Our ref: HA/2018/120921/01-L01
Your ref: LU/330/18/PL
Date: 13 December 2018

DEMOLITION OF EXISTING BUILDINGS & THE ERECTION OF 77 RESIDENTIAL HOMES WITH ASSOCIATED ACCESS, CAR PARKING, CYCLE PARKING, REFUSE/RECYCLING STORAGE, LANDSCAPING, EARTHWORKS & INFRASTRUCTURE

LAND SOUTH OF CORNFIELD CLOSE LITTLEHAMPTON BN17 6LD

Environment Agency Position

Conceptual Site Model

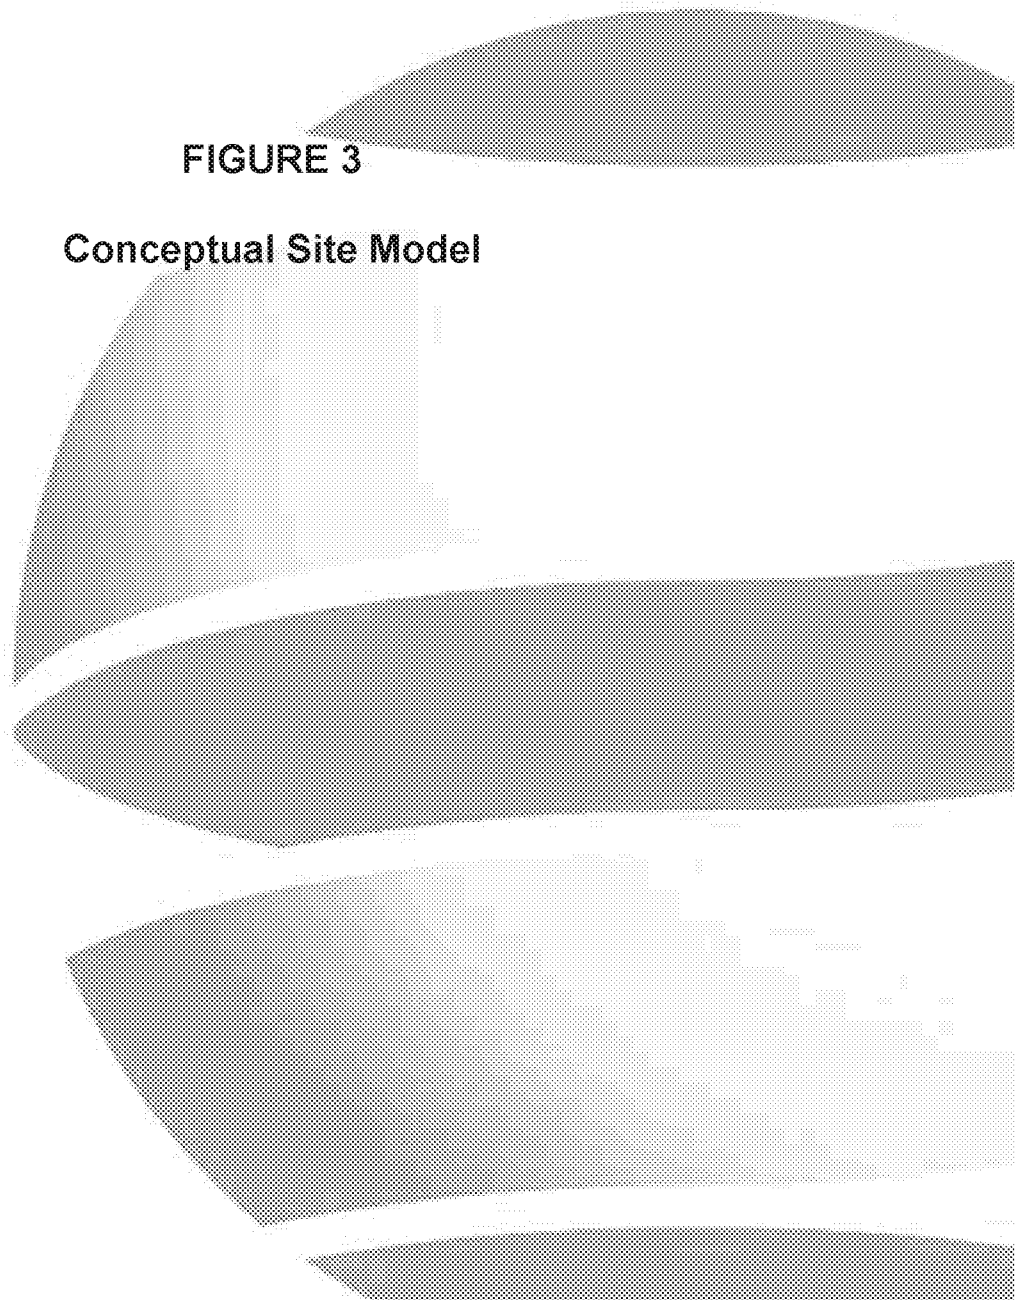
The site rests on River Terrace Deposits (Secondary A Aquifer) which have a highly seasonal groundwater influence and have good aquifer characteristics. These deposits are underlain by the undifferentiated Lower Chalk Group (Principal Aquifer). The potential transmissivity of the River Terrace Deposits is a significant pathway for contaminants reaching the Principal Aquifer and constitutes a significant risk to groundwater.

Site wide investigations should be able to clearly delineate the footprint of legacy industrial buildings. Additionally, further groundwater monitoring will be able to improve conceptual understanding of the impact of the landfill upon controlled waters.

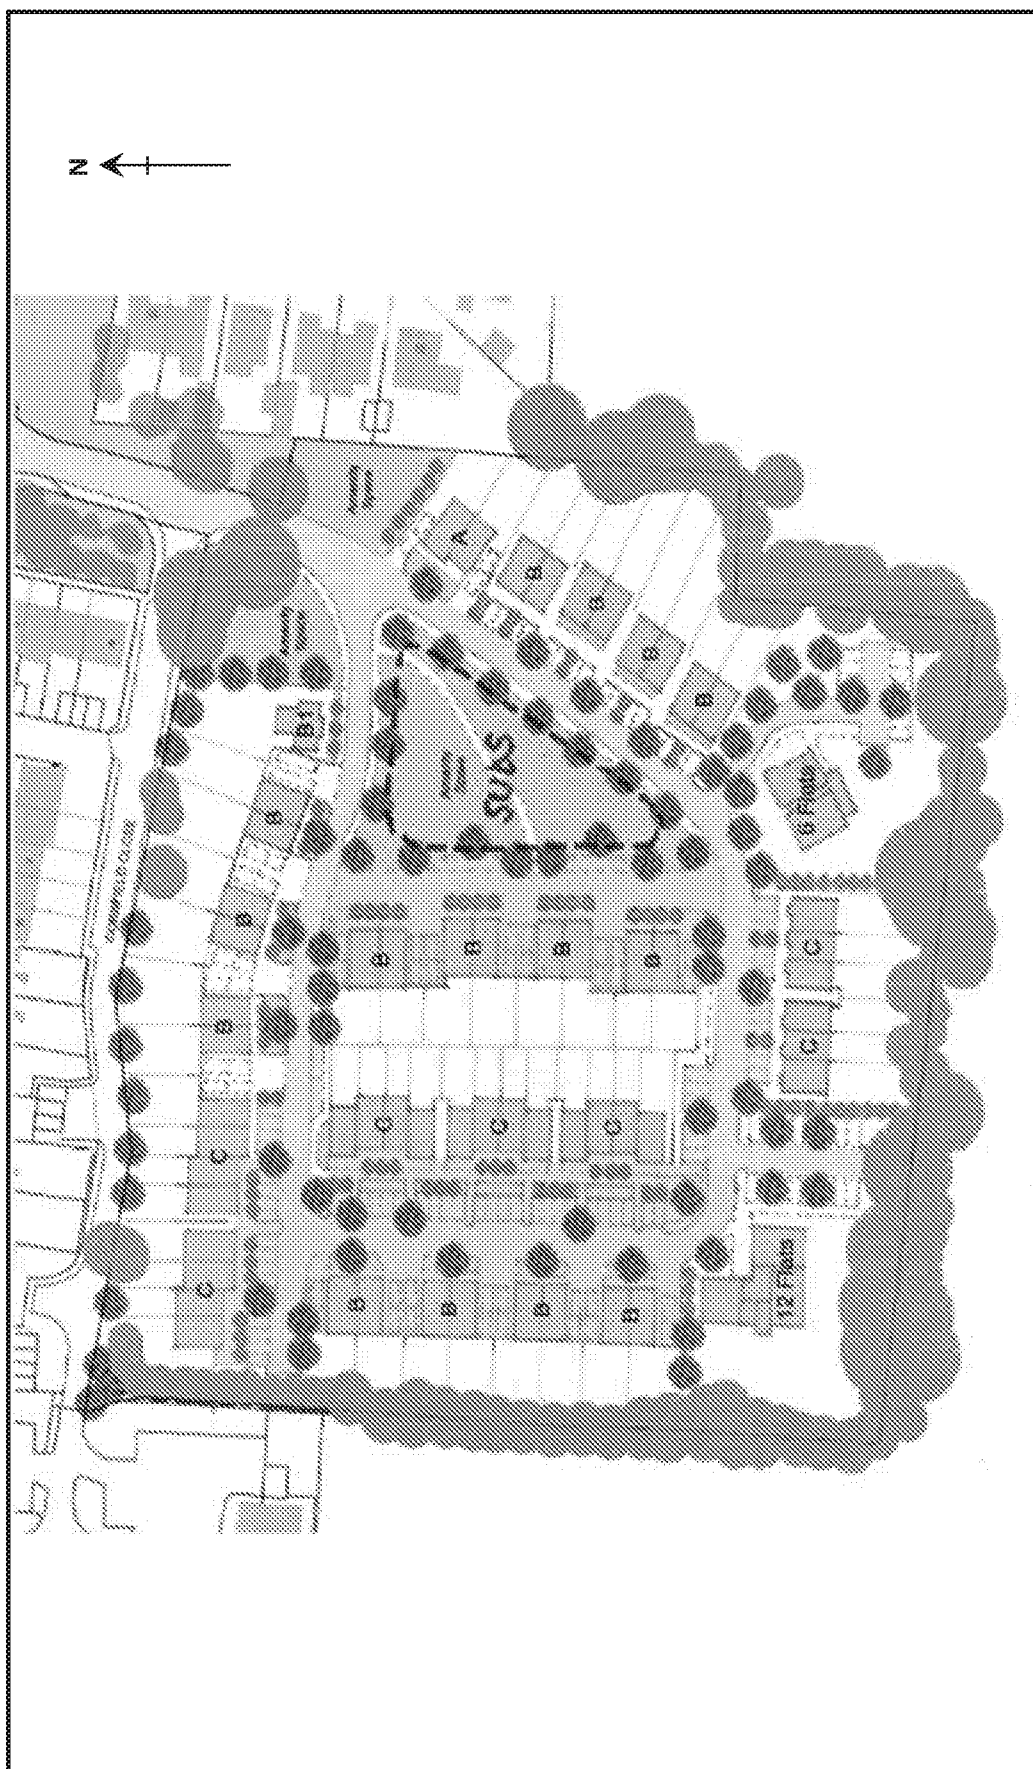
The previous use of the proposed development site as Brick Kiln and Landfill presents a high risk of contamination that could be mobilised by surface water infiltration from the proposed sustainable drainage system (SuDS). This could pollute controlled waters. Controlled waters are particularly sensitive in this location because the proposed development site is located upon a principal aquifer.

In light of the above, we do not believe that the use of infiltration SuDS is appropriate in this location. We therefore request that the above planning condition is included as part of any permission granted. Without this condition we would object to the proposal in line with paragraph 170 of the National Planning Policy Framework because it cannot be guaranteed that the development will not be put at unacceptable risk from, or be adversely affected by, unacceptable levels of water pollution.

No drainage systems for the infiltration of surface water to the ground are permitted other than with the written consent of the local planning authority. Any proposals for such systems must be supported by an assessment of the risks to controlled waters. The development shall be carried out in accordance with the approved details.
